Our ref: HA/2020/122070/01-L01
Your ref: LU/48/20/PL

DEMOLITION OF 1 NO. BUNGALOW & OUTBUILDINGS & ERECTION OF 22 NO. DWELLINGS WITH ASSOCIATED PARKING & OPEN SPACE.

SOUTHDOWN NURSERY, OLD MEAD ROAD, LITTLEHAMPTON, BN17 7PU.

In the absence of an acceptable Flood Risk Assessment (FRA), we **object** to this application and recommend that planning permission is refused.

DRAWING TITLE
Proposed Site Layout Plan

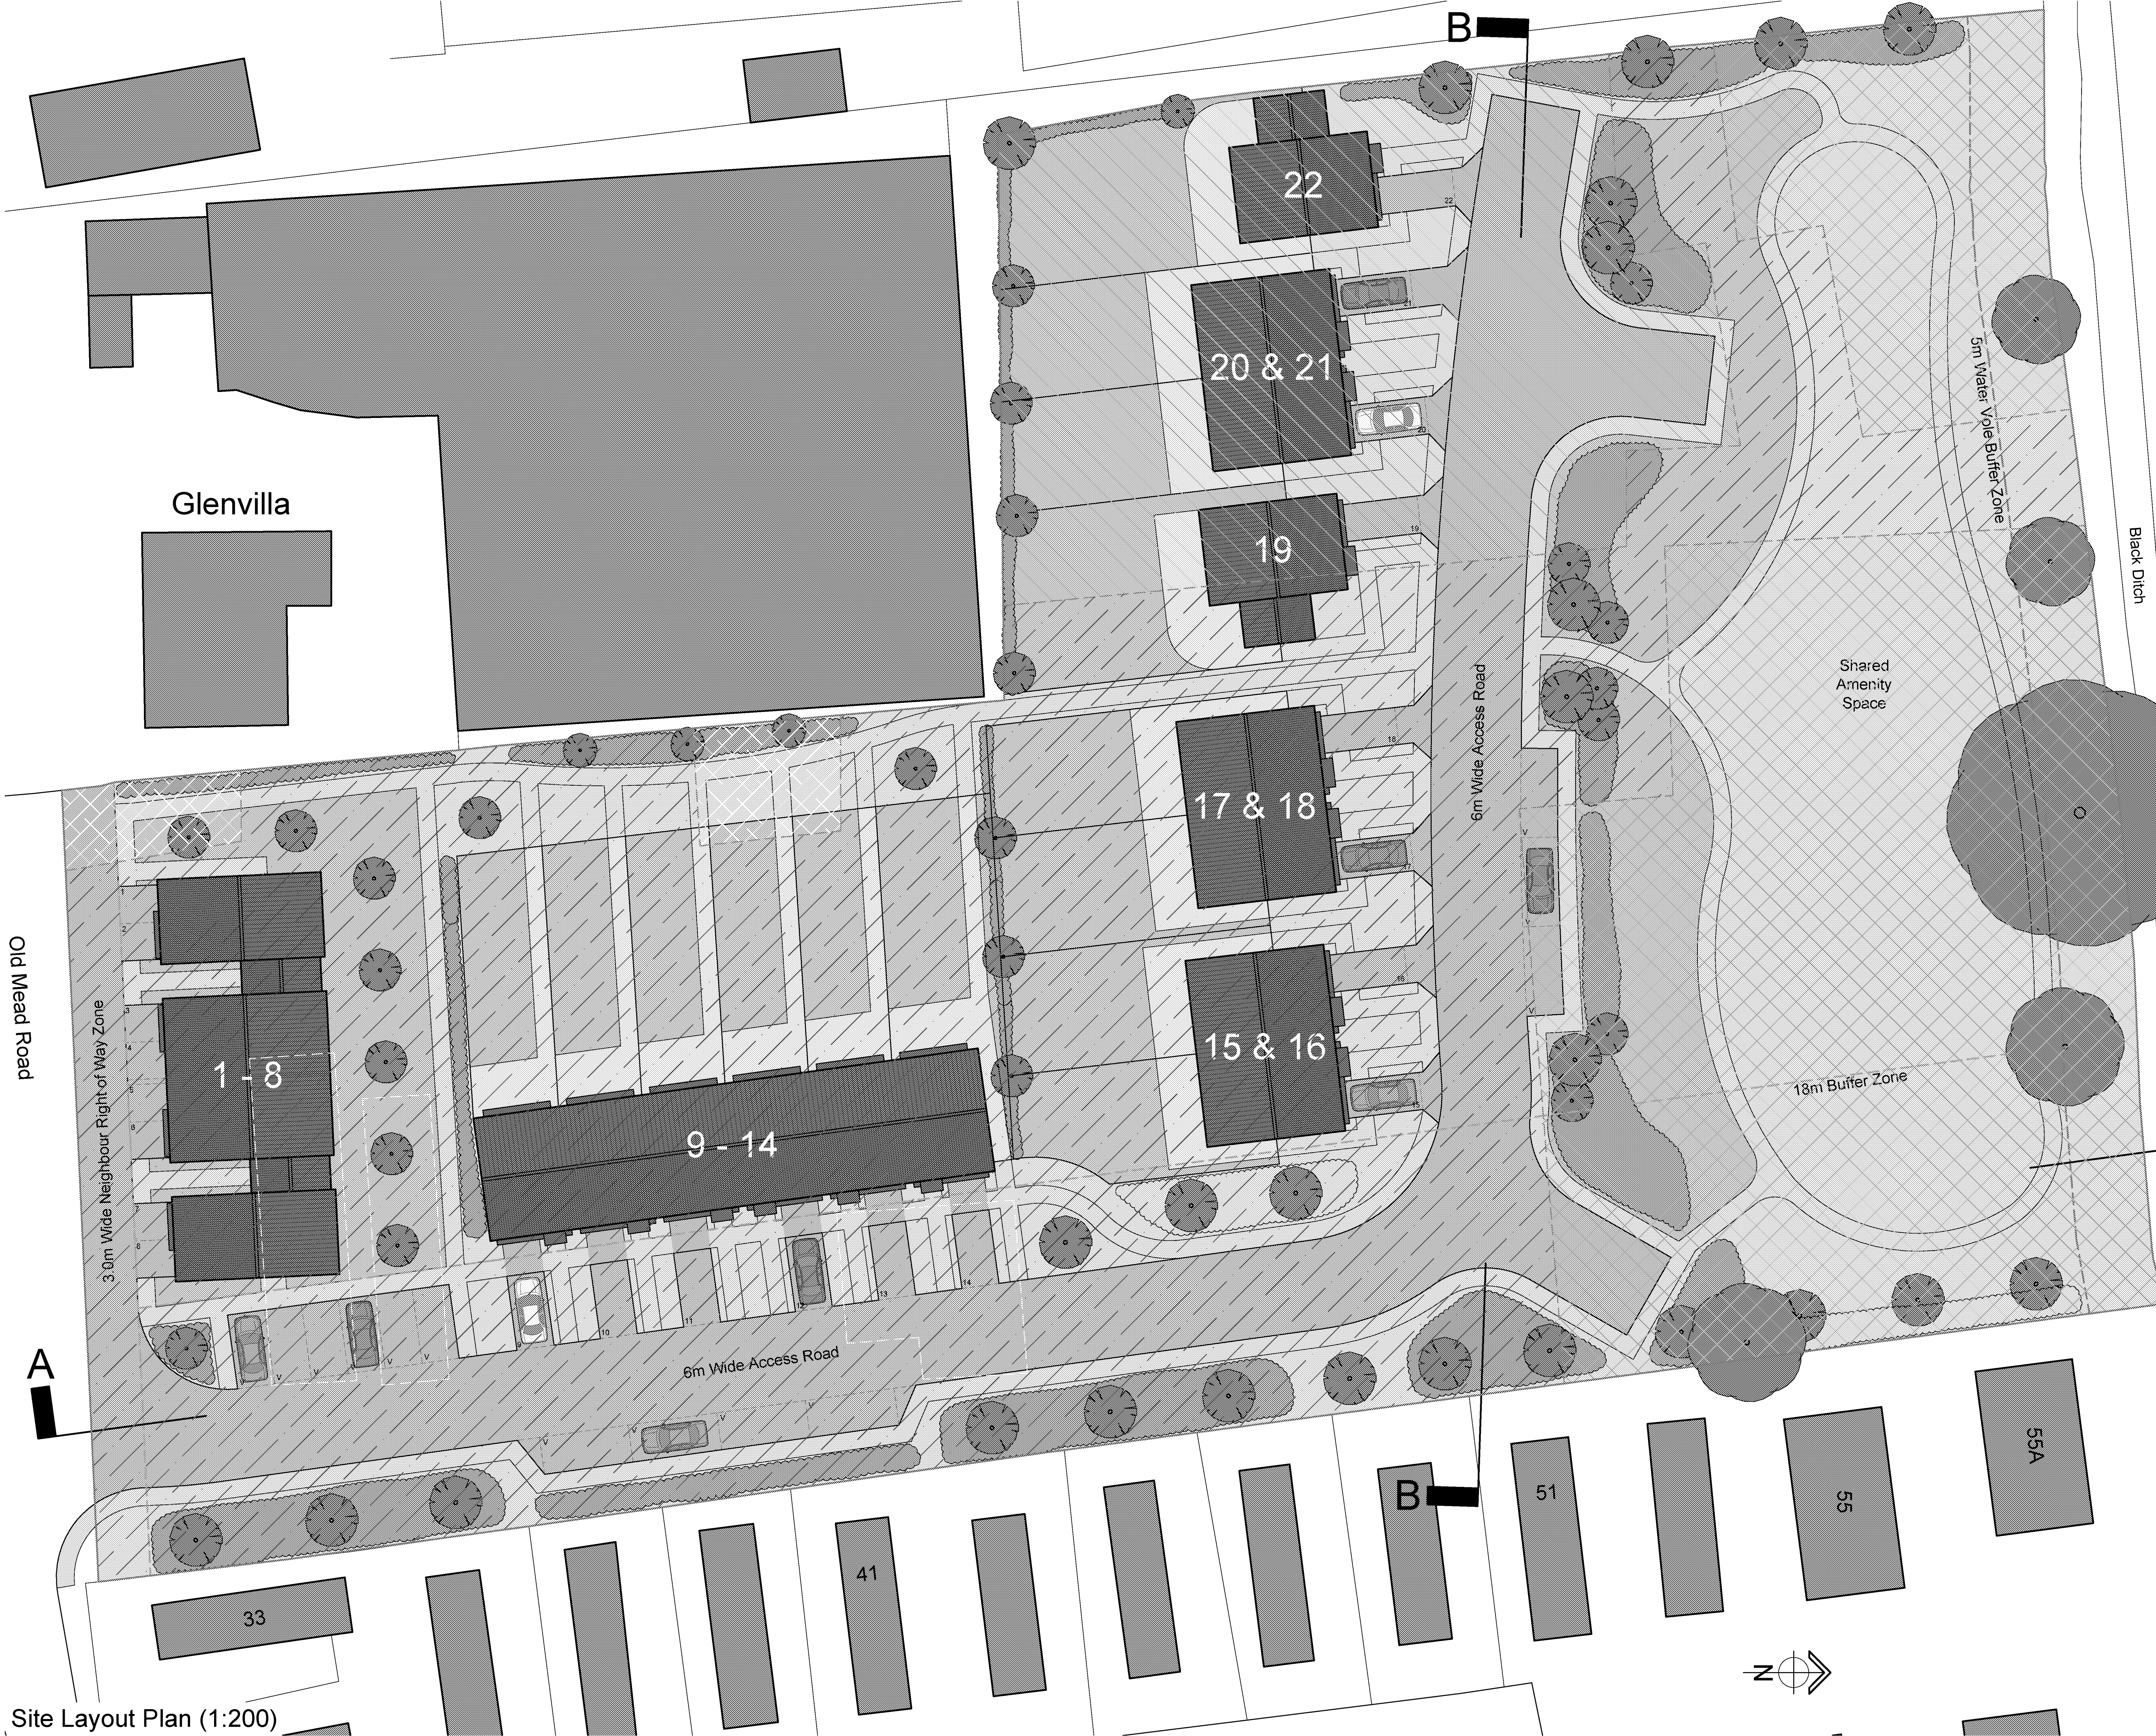
It is proposed to lower ground levels by 0.320m across the open space area to provide flood plain compensation. It is stated that 965m³ will be lost and that 973m³ will be provided as compensation. The compensation calculations are not shown in the FRA, and therefore it is not possible to determine if the quoted numbers are correct and enough flood plain compensation storage has been provided.

To ensure the principles of level for level compensation are fully adhered to, the Applicant should provide a series of cross sections of the area where the loss of flood plain occurs, and also of the correspondent flood plain compensation area.

The proposal to incorporate under floor voids is not a preferable option for flood plain compensation. Issues with voids include trapped debris and blockages under the buildings and silt accumulations, which is difficult to clean down after a flood event and can potentially lead to public health issues. On some occasions, due to the size of the void openings, maintenance could be entirely restrictive.

It will need to be demonstrated why a conventional scheme is not possible to be implemented, as well as a plan being agreed between the Applicant and the Local Planning Authority to ensure that the voids are managed and maintained for the lifetime of the development.
